November 29, 2012

Historical Preservation Board
City of Portland
389 Congress Street
Portland, Maine 04101

RE: Commercial and Middle Street Mixed Use Development
Foundry Lane comments, responses & revisions

DATE: 10-22-12  
 SCALE: 1"=20'  
 DRAWN BY: BJS  
**C04**  
 SHEET: 4 OF 14

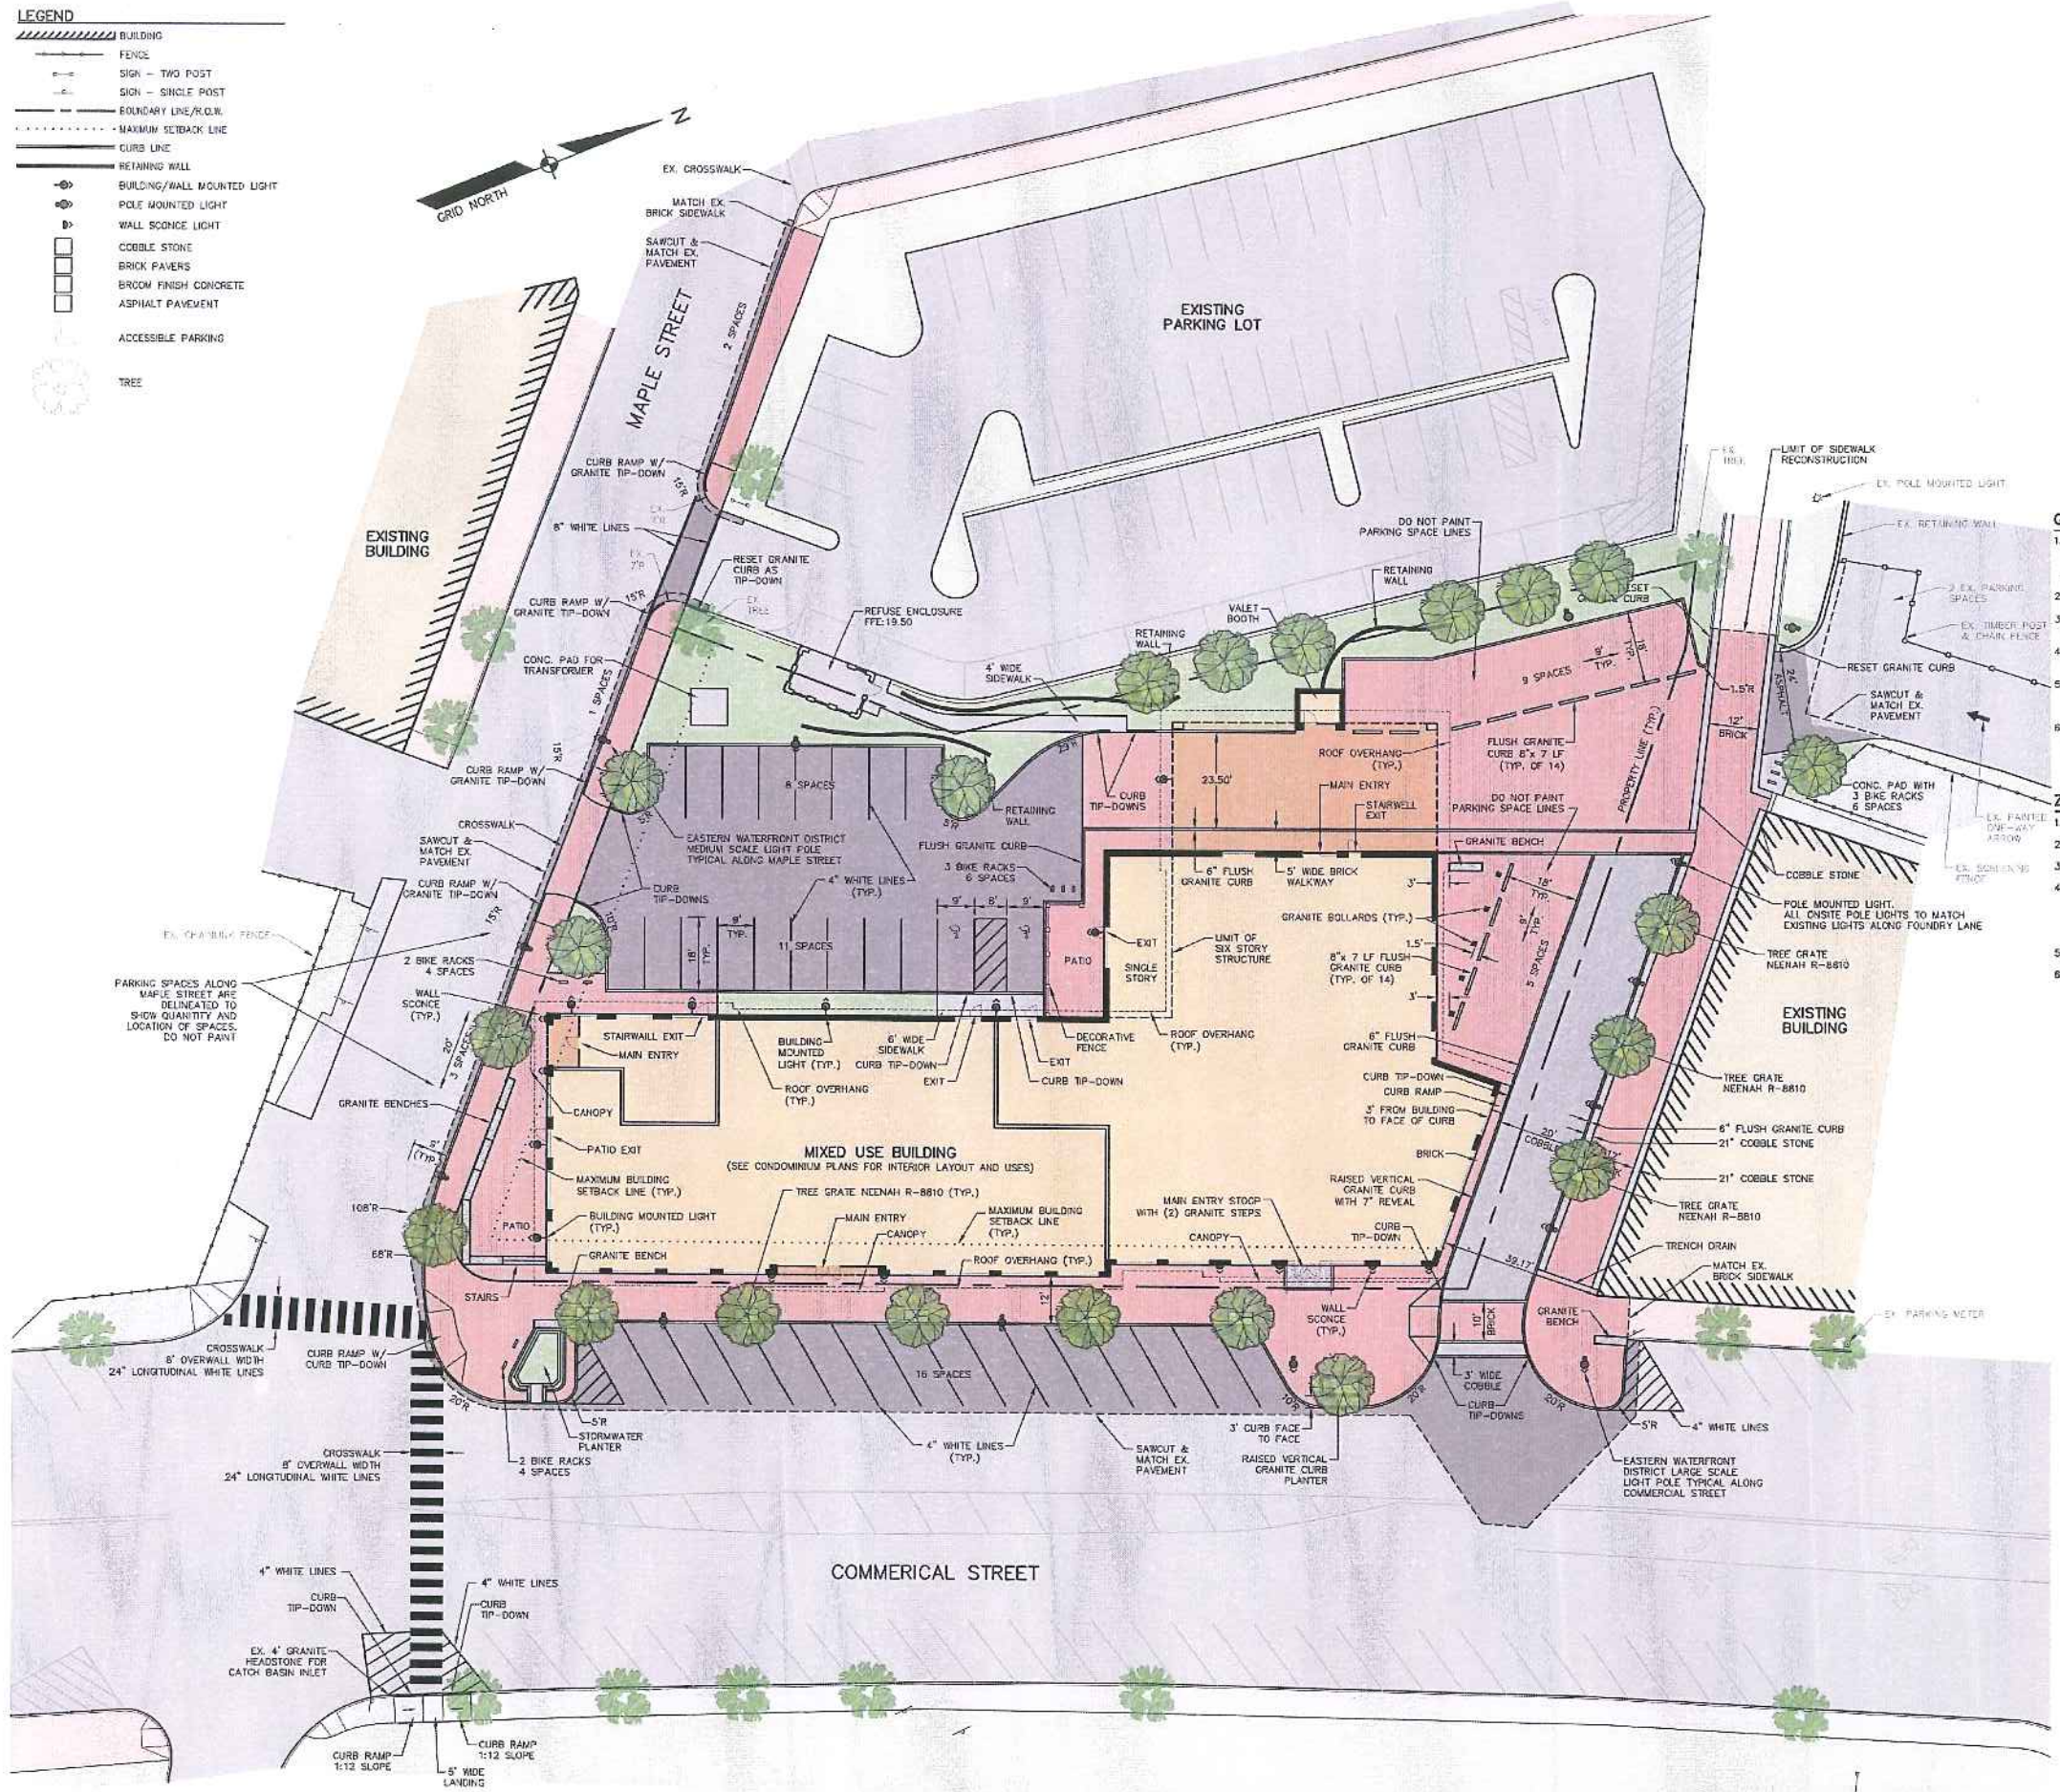
- The general concept is acceptable; the 22-foot entry width is acceptable. A few comments:
- The driveway at the location of the compact parking space is very tight. A vehicle parked in that space will extend out into the driveway and will reduce the effective width. A detail of this area illustrating how it will work is suggested.

- The applicant should provide a turning template for the three parking spaces where the parking aisle is only 18 feet wide. In general I think it is workable, but I'm not sure if the bollard is going to be a problem.

- Moving 2 of the trees along Foundry into the adjacent large triangular areas, with large planters to give them maximum room for soil and water; these areas suggested curbed with landscape rather than hard surface (Deb Andrews considers that the one nearest Commercial Street should be soft landscape edged with granite/cobbles for all of the triangular area, including the area of the bike racks, so that the 9 ft walkway section reads as a separate linear feature);

- Suggest a row of cobbles or granite stone at the back edge of each of the parking spaces (not continuous; one line of cobbles or linear stone for each space) would help delineate parking spaces and break up the expanse of brick (it is assumed there will be no striping)
 - ***We have implemented this revision.***
- Please specify the width of the cobble band along each side of the new section of pedestrian walkway and also along the existing section
 - ***A picture of the existing cobble bands below depicts 4 rows of cobbles running parallel with the brick walkway and generally a single cobble is 5" in the applicable dimension. With that said, the existing cobble bands are generally 21 or 22 inches in width. It is our intent to provide 4 rows of cobbles as the picture below. The Conceptual Plan depicts a 21 inch width for the proposed cobble bands.***

- Cobbles within Apron: I am waiting for confirmation from DPS that the cobbles are OK in the ROW - will get back to you but leave them in for now. Please specify width.
 - ***The Conceptual Plan depicts a 3 foot width. This will be approximately 7 rows of cobbles.***

- The original submitted plan for Foundry Lane (CO4, as submitted to Planning Board) showed 2 pole-mounted lights adjacent to the new walkway that gave light coverage to the new section of pedestrian walkway and continued the row of lights (see photo attached) that are along the existing walkway leading to York Street. I'm not sure the lights now proposed near the hotel will adequately light the central section of the new section of walkway and suggest some additional lighting should be incorporated to adequately illuminate the new section of the pedestrian walkway and address CPTED standards.

- ***The compact parking space is 15 feet in length as required and signage will be utilized to indicate compact cars only. Compact vehicles 15 feet in length or shorter will not extend into the parking aisle. To assist motorist in identifying parking space locations and length, we have added a flush granite stone "header" within the brick pavers. In addition, I have added parking aisle dimensions at this location to indicate a 22 feet at the aisle's most narrow width. This width will accommodate the turning maneuvers of a compact vehicle. A detail utilizing the turning template of a compact vehicle can be provided if the reviewer still deems it necessary.***

- ***The fire department has indicated they require 20 ft wide access roads. Thus we have revised this parking aisle width to 20 feet. In addition, the three parking spaces mentioned above are angled slightly provide smoother turning maneuvers in and out of the parking spaces along this one-way parking aisle. Further, two raised curbed islands have been added to the plan. One of the islands is in this location, and as a result, we have reduced the number of granite bollards and their location. The granite bollard specifically mentioned above has been deleted from the plan.***

- ***We have revised the proposed lighting along Foundry Lane. The intent of the revisions is to use the lighting to further help Foundry Lane read as a separate linear feature to the driveway and walkway along the proposed building. In Foundry Lane, we are now proposing a rhythm of pole mounted lights and trees along walkway. The lighting mounted in a post-top configuration and will have circular distribution to equally illuminate the walkway and the parking spaces. Along the proposed building, we are proposing a rhythm of building mounted lighting with forward light distribution to illuminate the 5' walkway and driveway. Also, we are revising the light fixtures in this area to match the existing lights along the existing Foundry Lane to the northwest. The mounting of the lights will be different to better accommodate light distributions. Please see the below examples. A photometric plan will be provided to Planning pending the Historical Preservation Board's feedback.***
